Online Comment

Application H16-0138-18
Location 20 - 21 HALL PLACE SPALDING PE11 1SQ
Proposal Proposed new shop front

Name Spalding & District Civic Society
Address Mr Robert West 94 Spalding Common Spalding PE11 3AU

Proposed Shopfront Plan | Scale 1:20@A1

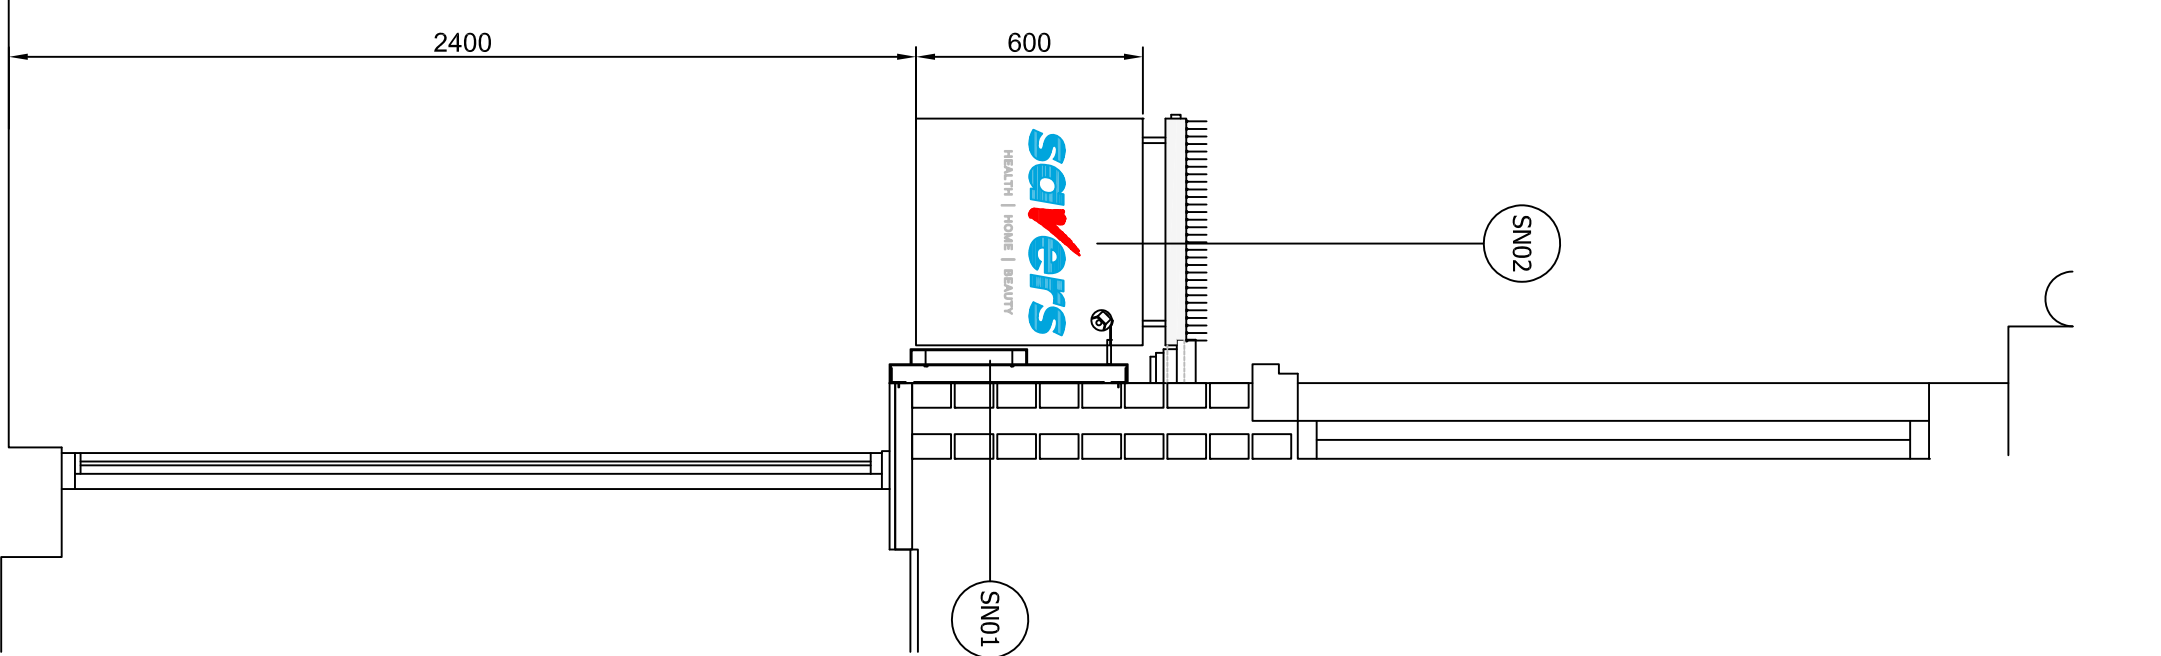
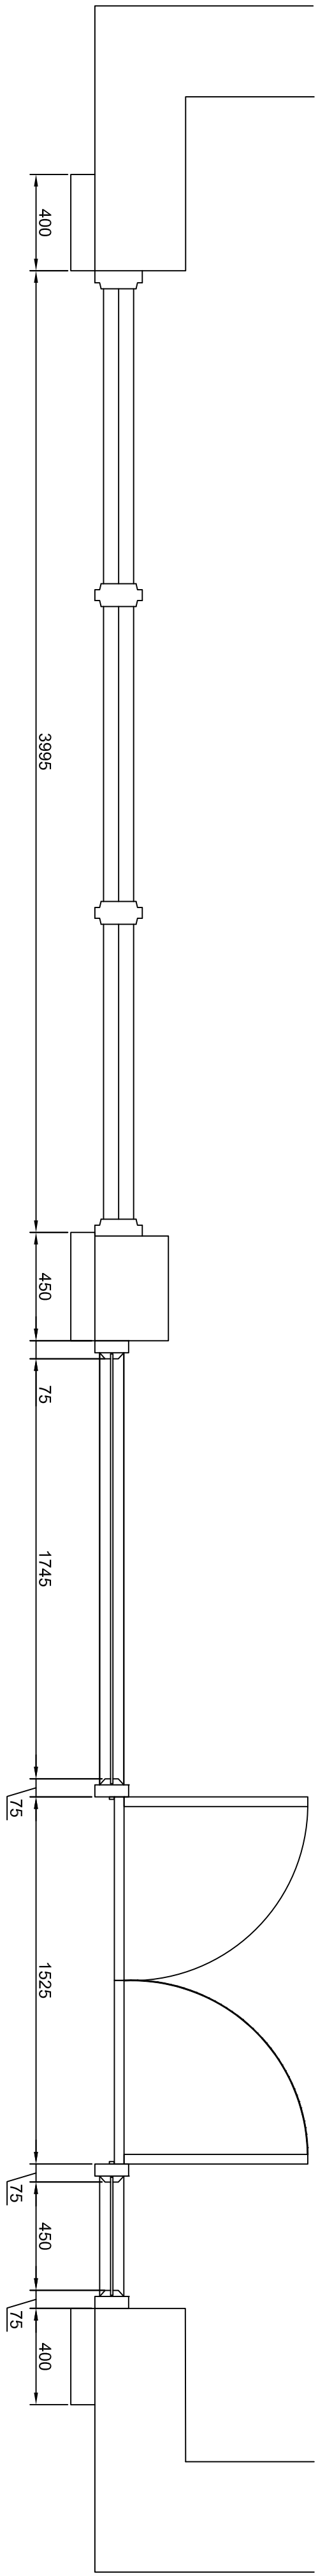
Shop front: Savers has a quasi-traditional shop front, so alterations should aim to strengthen its traditional elements. Unfortunately, these proposals do the opposite, diluting them by covering the moulding of the pilasters etc. by flat boarding. We recommend that this aspect of the proposal be refused and that the existing be retained. Or, better still, it should be re-submitted with enhanced traditional features, as set out in the SHDC Planning Information document 'Shop Fronts - Design'.

Signs: We find the proposals for the projecting sign and the fascia acceptable. However, those above the fascia are completely unacceptable.

a) The blanking-out of windows by vinyl film denies their very nature and is unacceptable at any time (remember my interview on Look North?), all the more so as this is a 19th century building whose wooden sash-windows retain the original slender glazing-bars characteristic of windows of this date. b) The strident, garish colour and wording amount to blatant advertising, contrary to council planning policies, which forbid signs above fascia level. c) and it is of course duplication, with the premises absurdly identifying themselves seven times over all told. We recommend refusal of all signs above fascia level.
